**Item No.**                      **Report of the Interim Director of Planning, Regeneration & Public Realm**

**Address**                      60 LONG LANE ICKENHAM MIDDLESEX

**Development:**              Demolition of existing dwelling and erection of two storey detached building with habitable roof space to provide 8 x 2-bed flats and 1 studio flat with associated amenity space and parking.

**LBH Ref Nos:**                **70282/APP/2022/1143**

SOUTH EAST ELEVATION

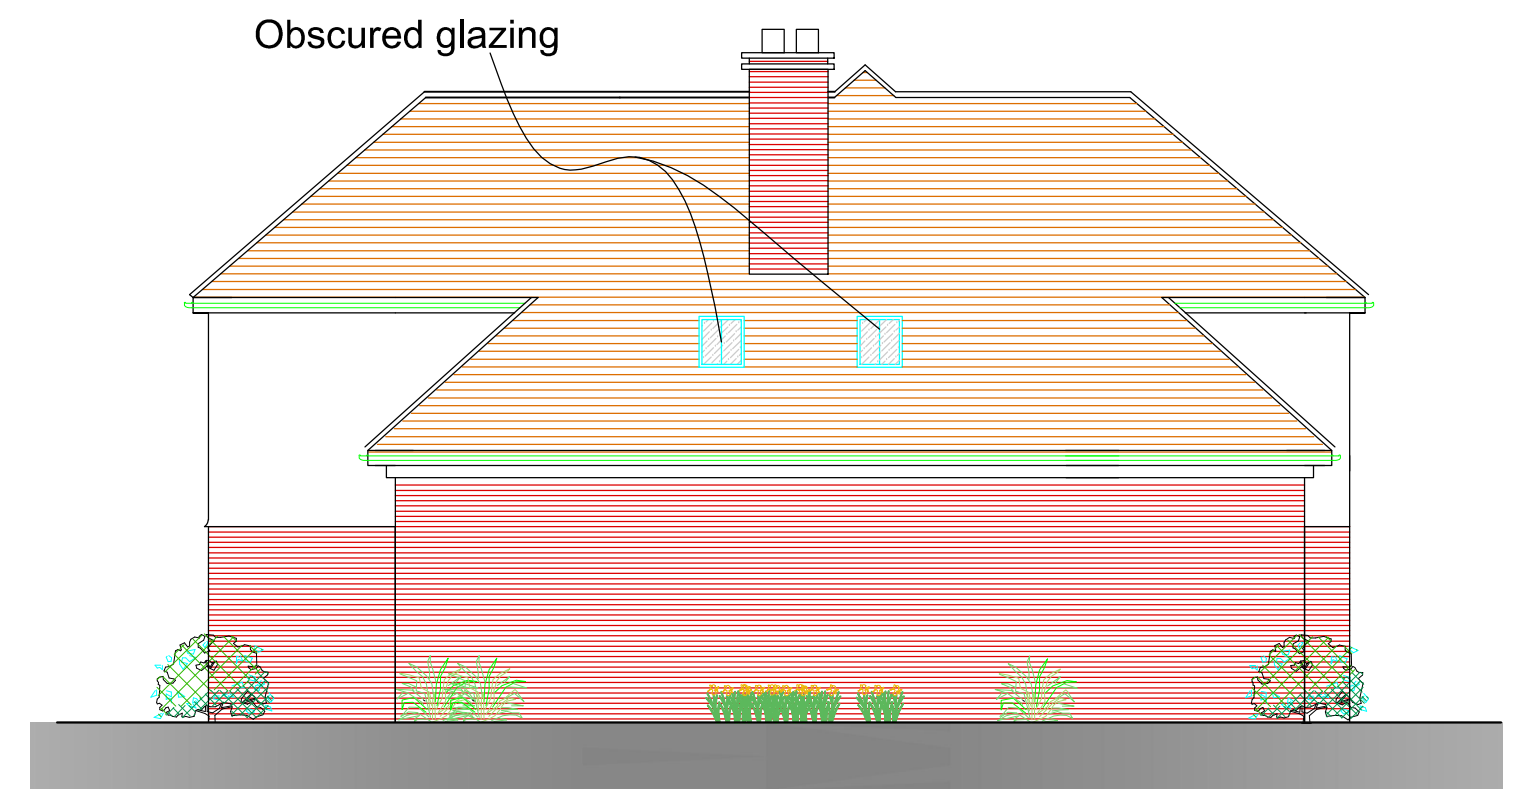
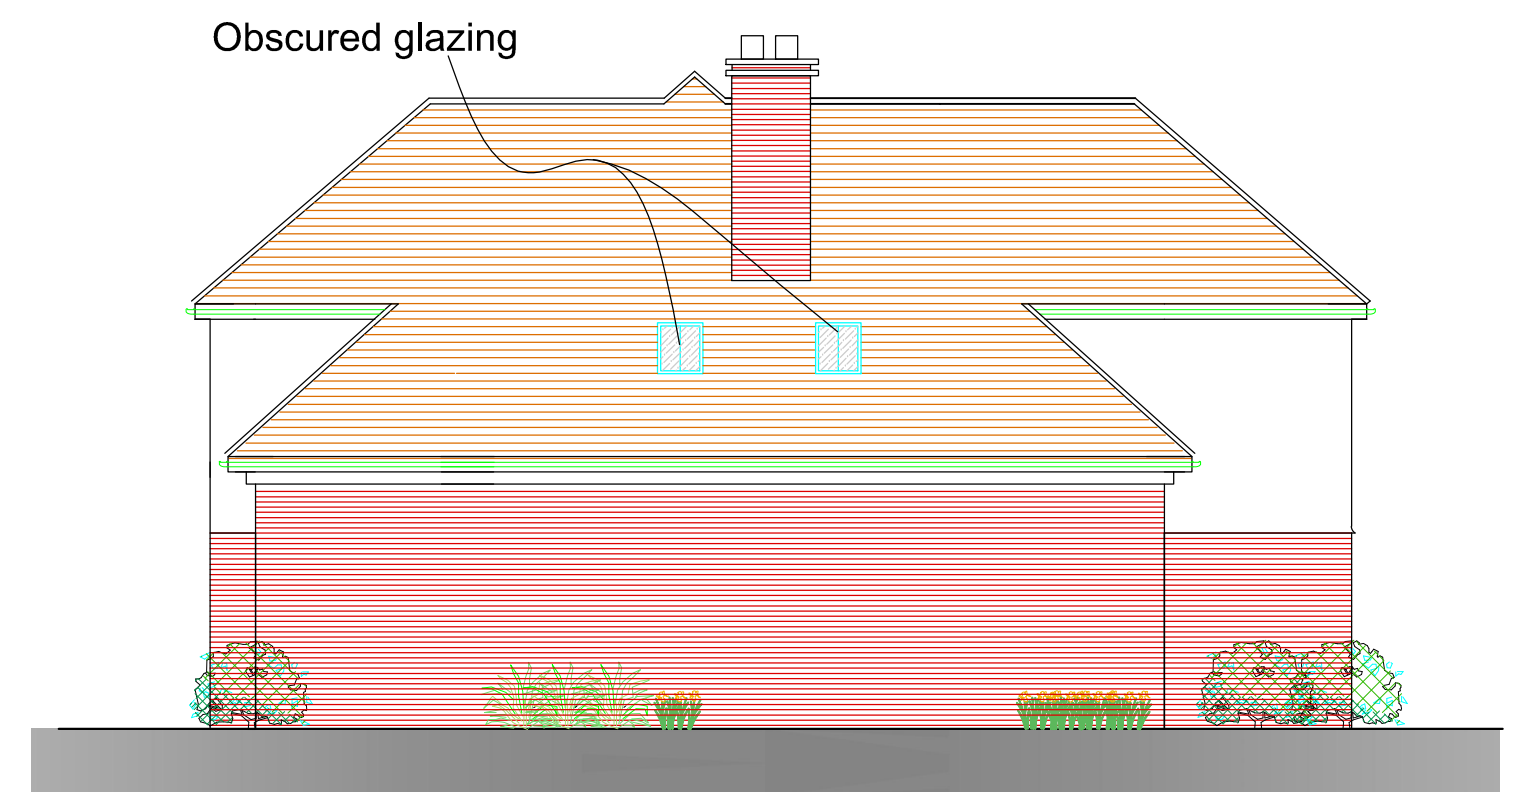
The proposed development, by reason of its size, scale, massing and design (including its uncharacteristic crown roof profile and lack of detail in respect to the height of the proposed sky lights) , would fail to harmonise with the character and architectural composition of the surrounding properties, appearing as a visually dominant, incongruous and bulky form of development which would be detrimental to the visual amenity of the street scene and would neither preserve or enhance but harm the character and appearance of the surrounding Conservation Area. The proposal therefore conflicts with Policies BE1 and HE1 of the Hillingdon Local Plan: Part One- Strategic Policies (2012) and Policies DMHB 1, DMHB 4, DMHB 11 and DMHB 12 of the Hillingdon Local Plan: Part 2 - Development Management Policies (2020), Policies HC1, D3 and D4 of the London Plan (2021) and the National Planning Policy Framework (2021).

4.5. Crown roof elements are not an established feature in the conservation area and tend

to indicate that the development is too deep. Well-designed new builds should be able to avoid the need for crown roof elements.

LOFT PLAN

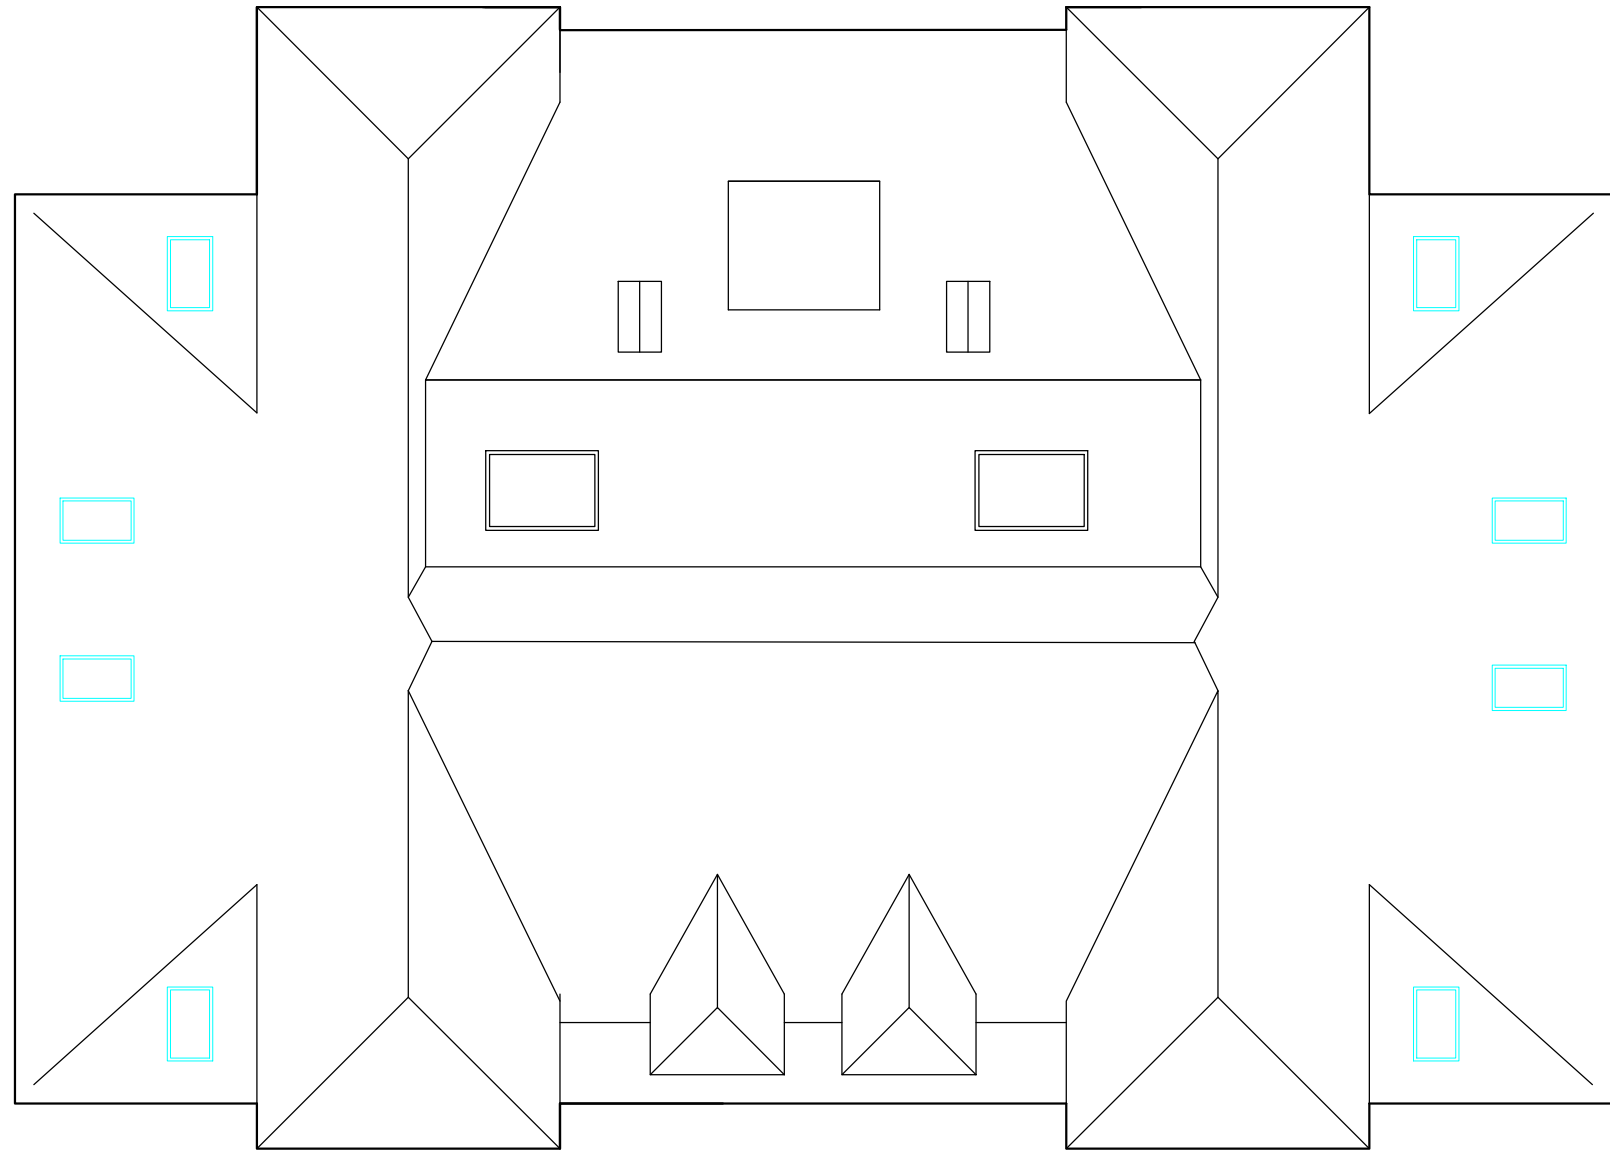
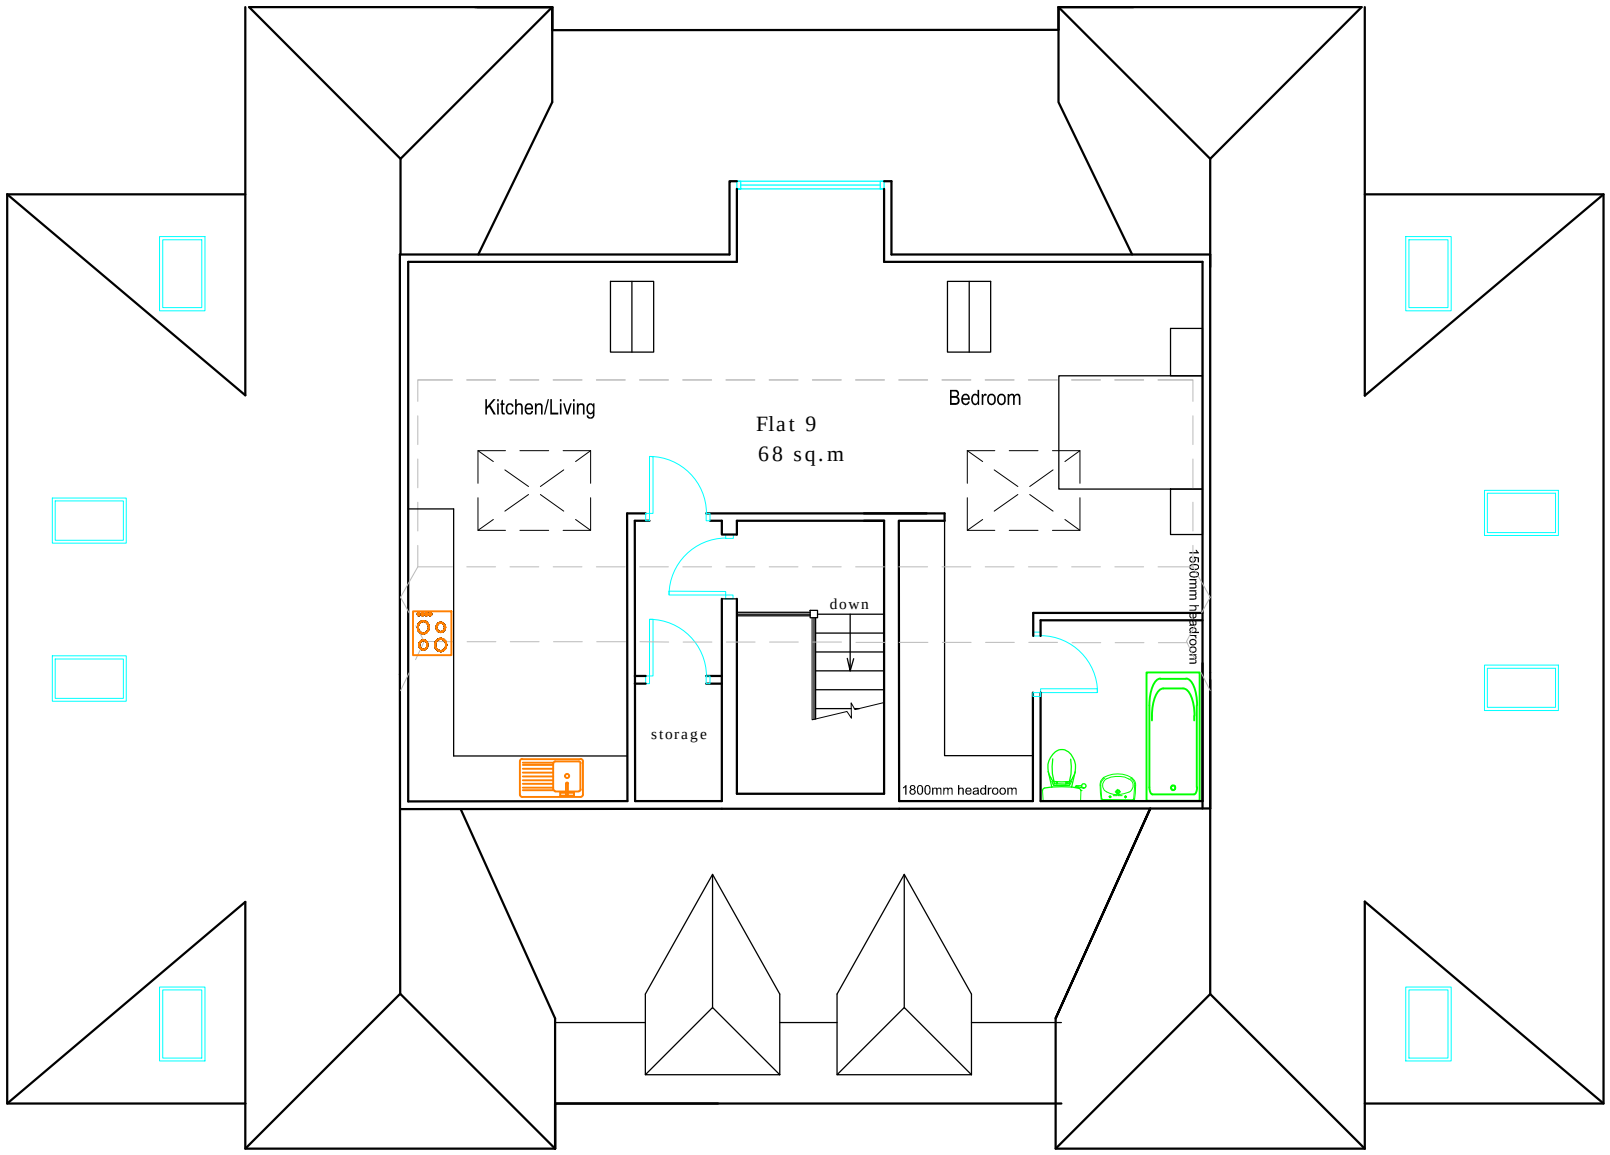
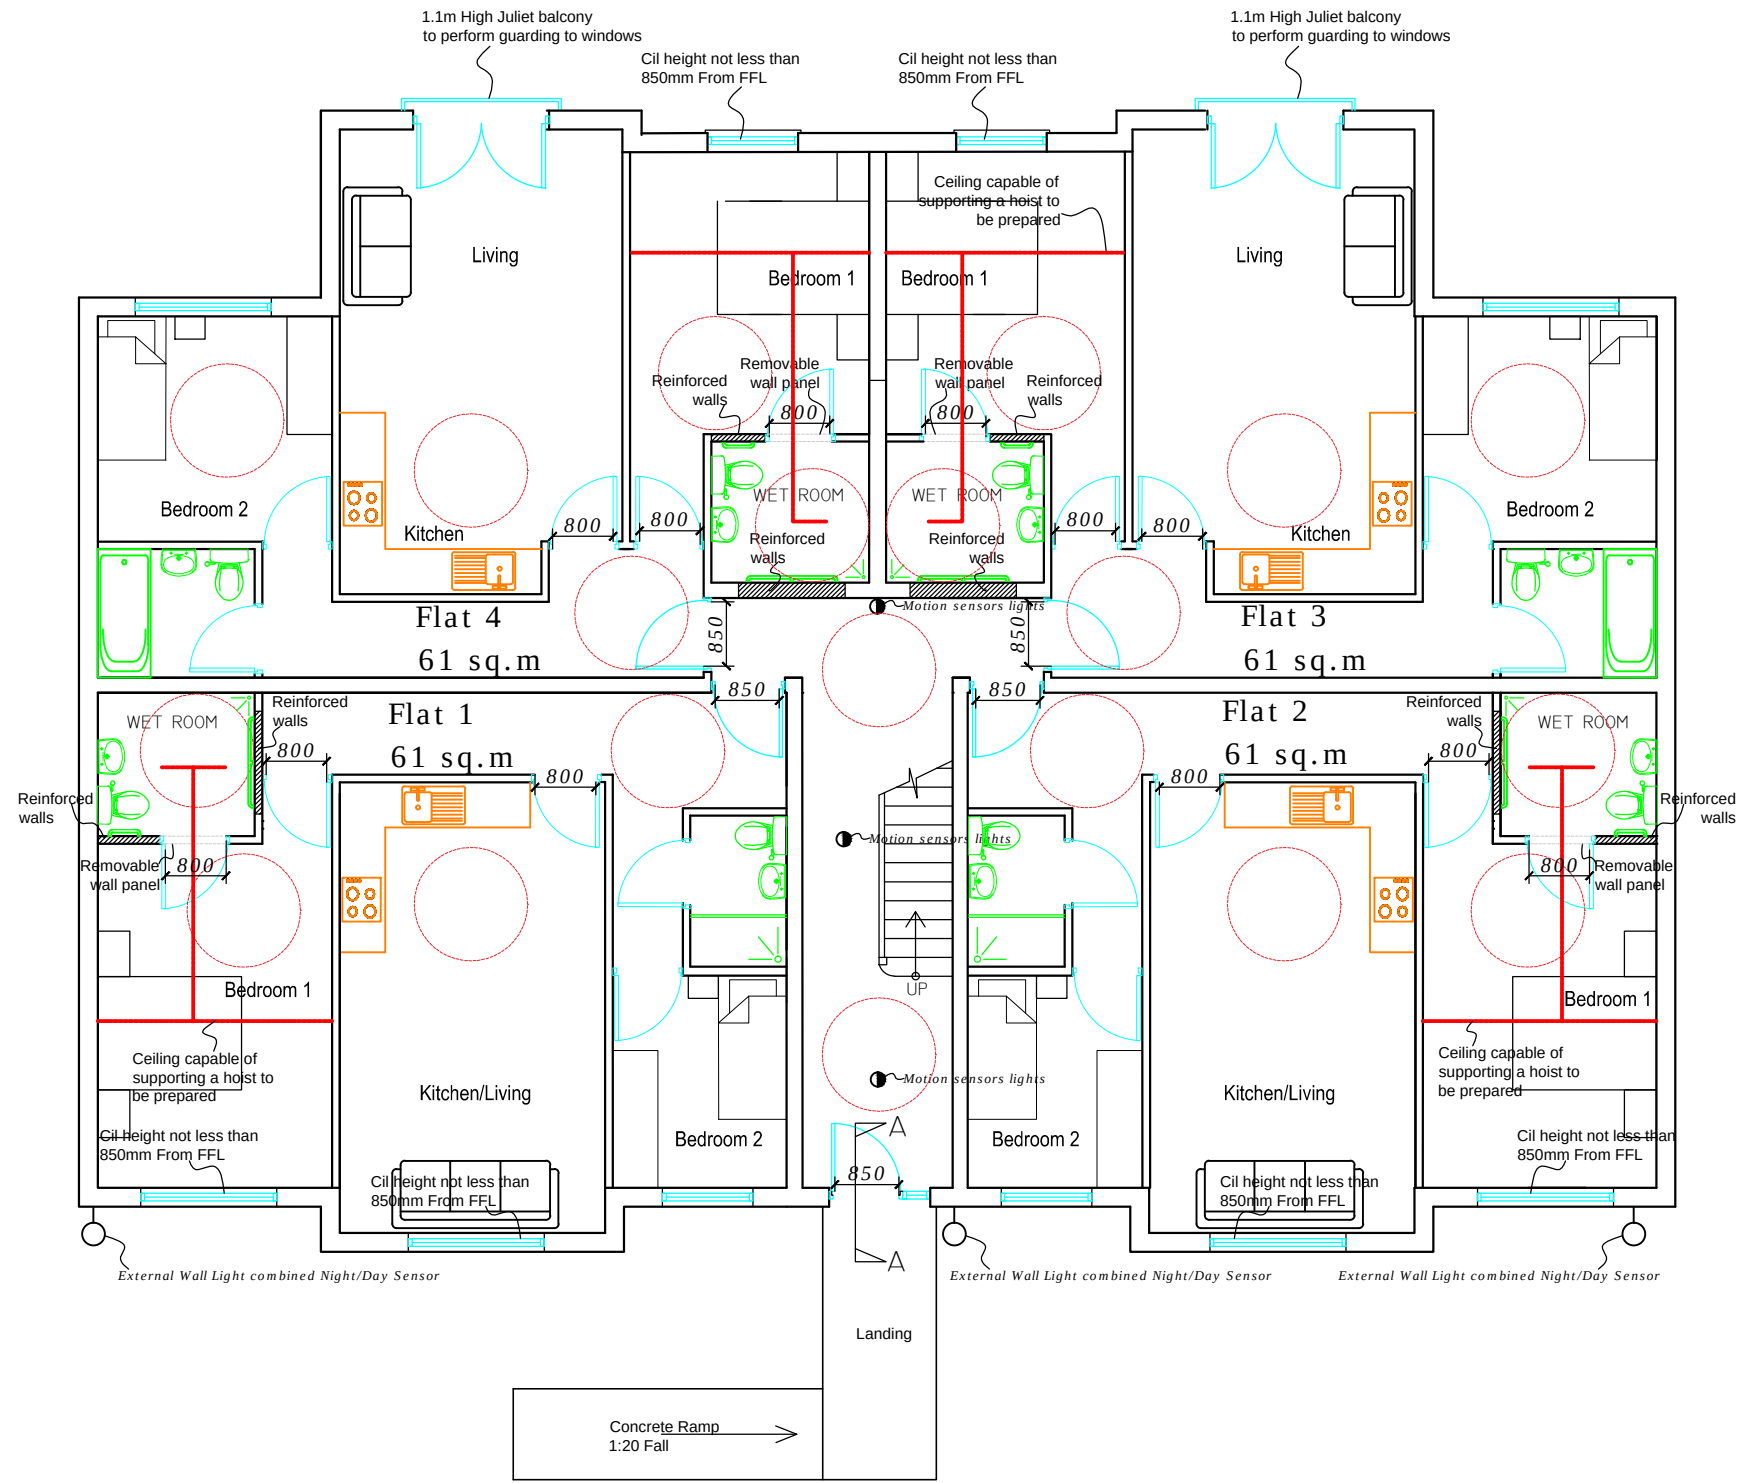
The proposed development, by virtue of the internal layout of the loft space and position of the proposed rear dormer, skylights and roof lights, would result in poor outlook and an oppressive living environment for the future occupiers of Flat 9. The proposal would therefore result in substandard forms of residential accommodation to the detriment of the amenity of future occupants of the proposed development, contrary to Policy DMHB 16 of the Hillingdon Local Plan: Part Two - Development Management Policies (2020), Policy D6 of the London Plan (2021) and the National Planning Policy Framework (2021).

4.6. There would be significant concerns in terms of the quality of the Flat 9 within the roof space, with outlook limited to 2 rooflights and a dormer window.
